Application for a non-material amendment following a grant of planning permission.

I HAVE PREVIOUSLY BEEN GRANTED PLANNING PERMISSION FOR AN EXTENSION TO THE REAR OF 181A. I WISH TO SHORTEN THE PROJECTION FROM THE HOUSE FROM 4500mm TO 4050mm PLANNING APPLICATION 2016/1081. THERE IS ALSO A CHANGE TO FOUNDATION TYPE.

2016 / 1081

16-047 02 REV A

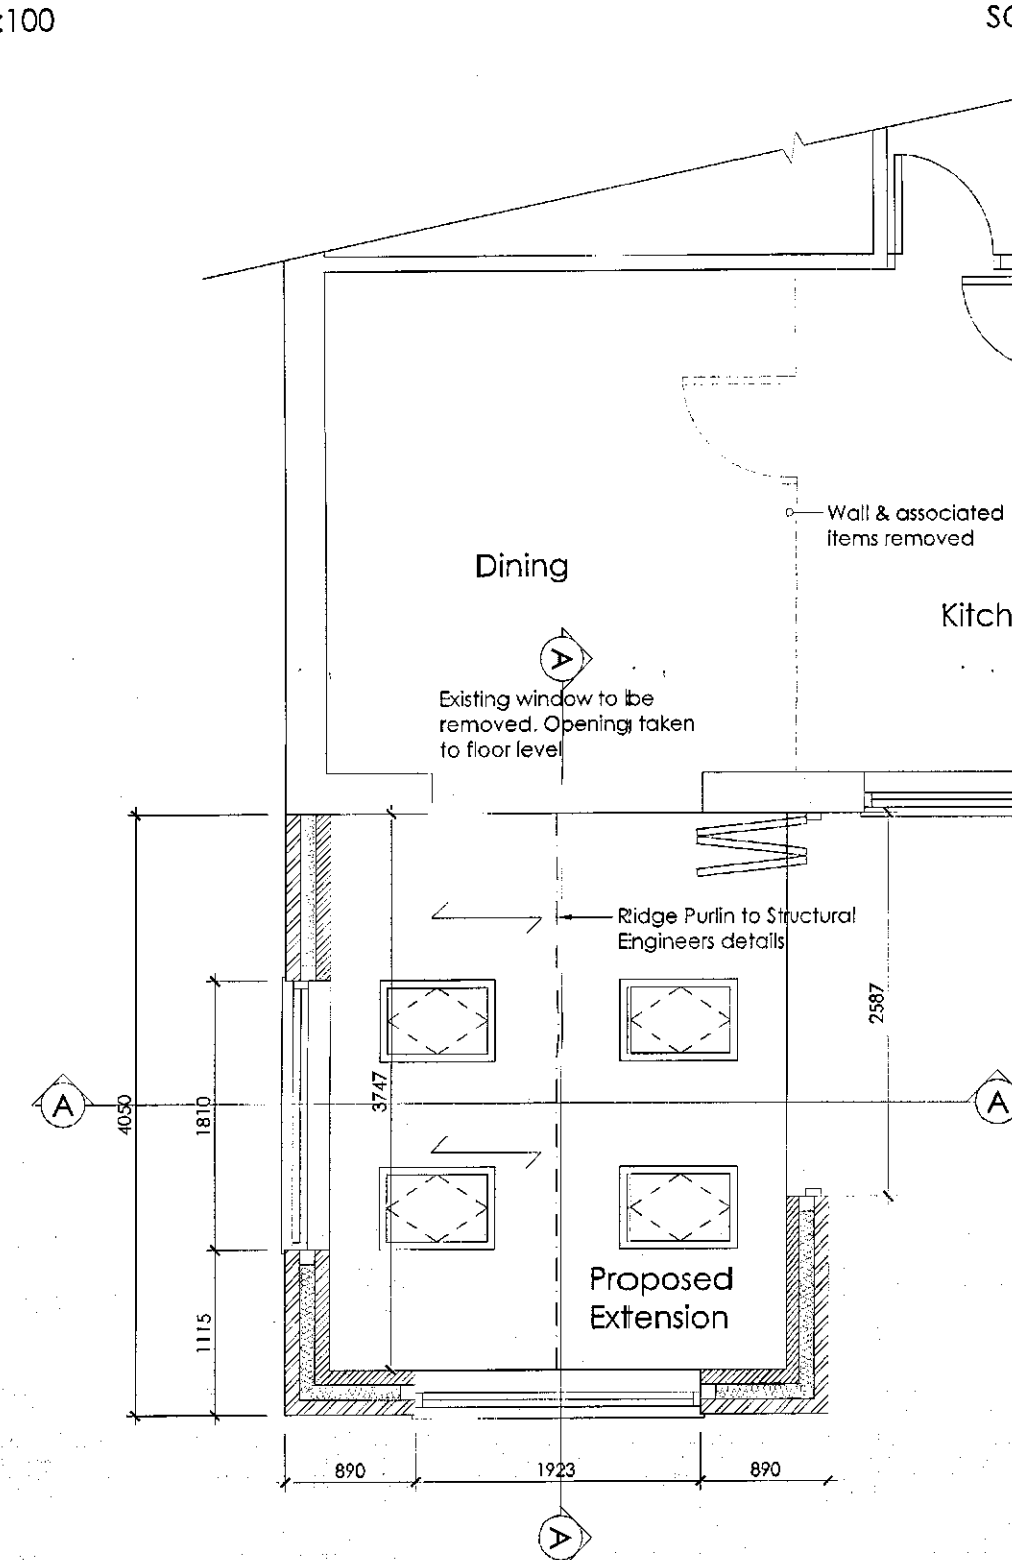
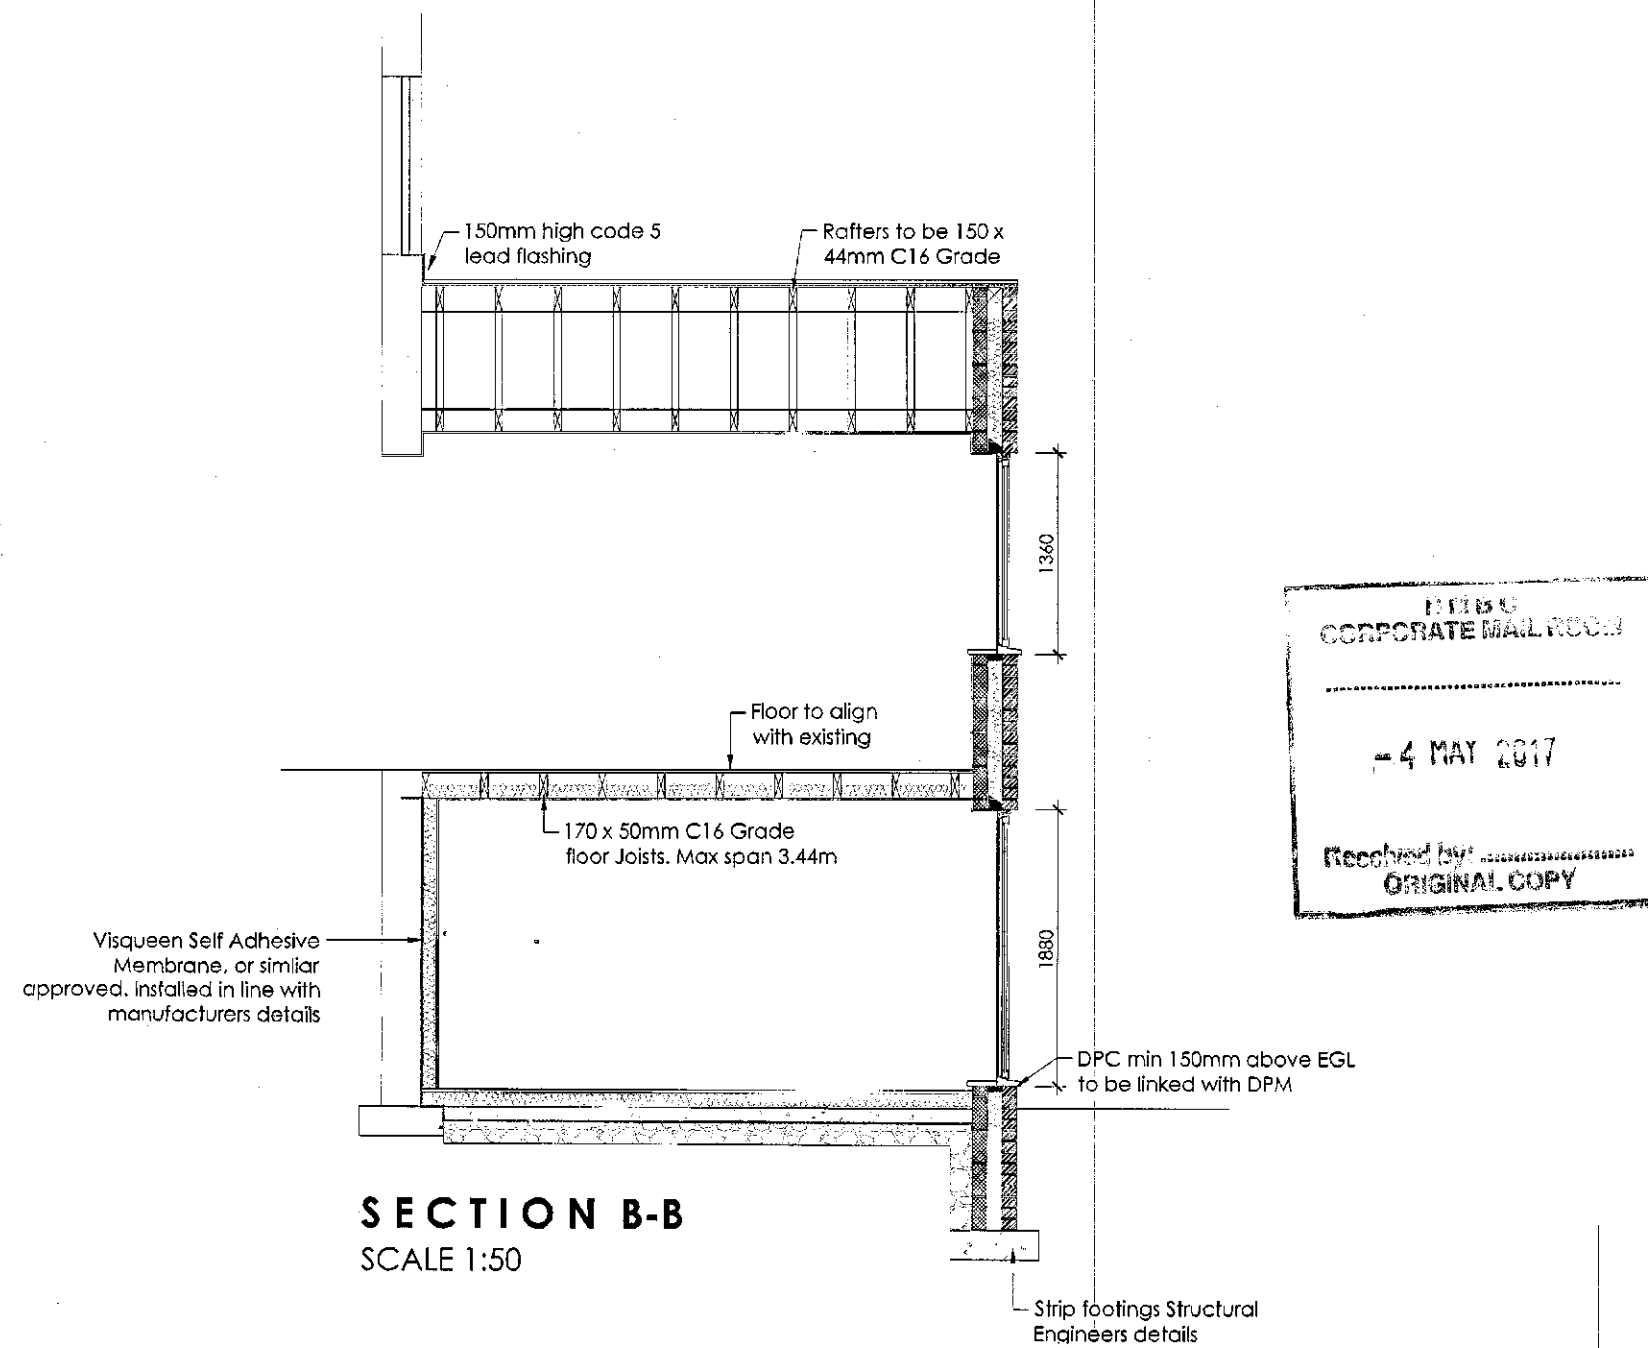
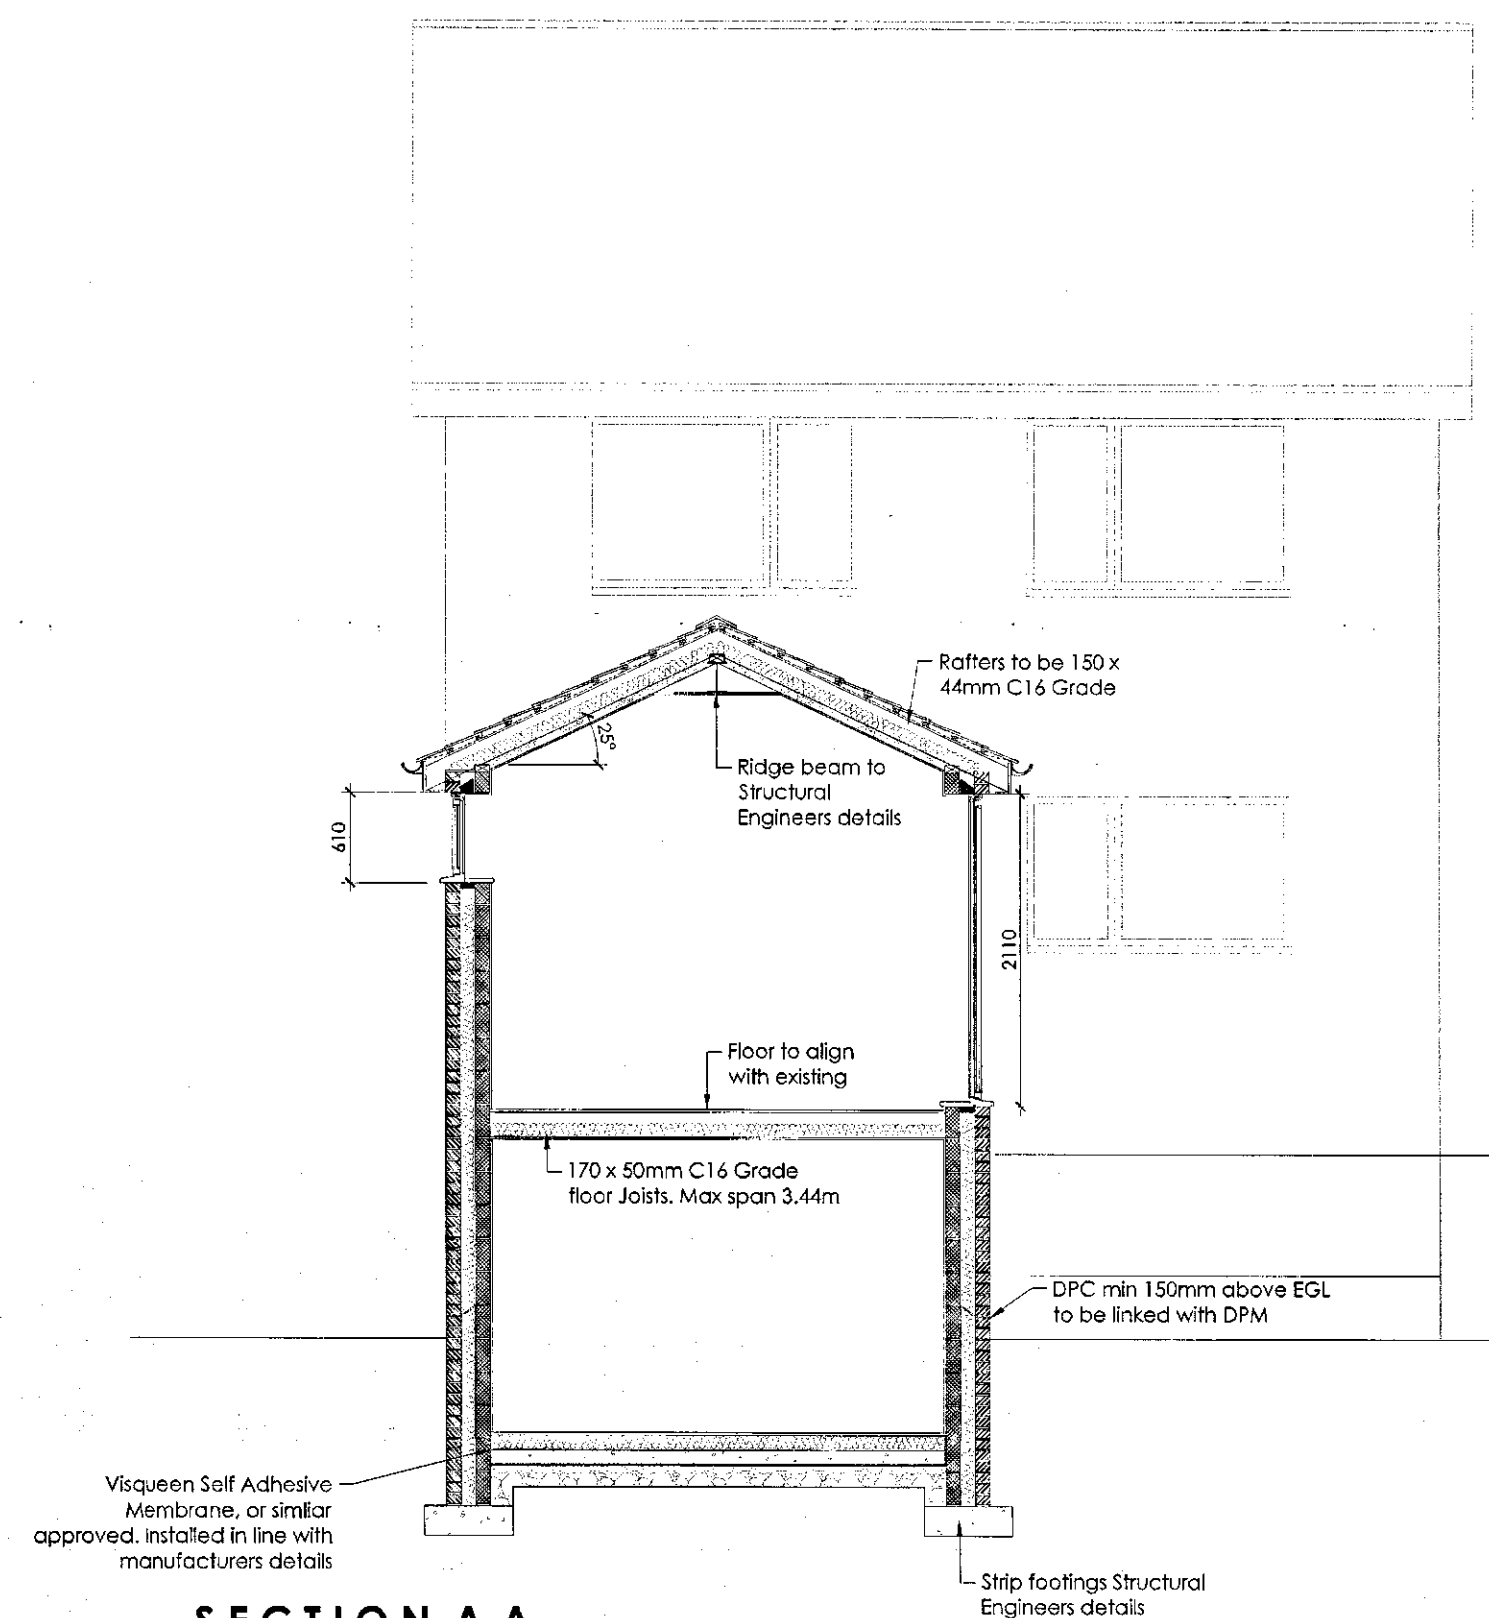
SHORTEN PROJECTION BY 450mm & CHANGE FOUNDATION TO STRIP TYPE FROM RAFT.

THE EXTENSION WOULD BE TOO CLOSE TO THE GARAGE.

16-047 02 REV B
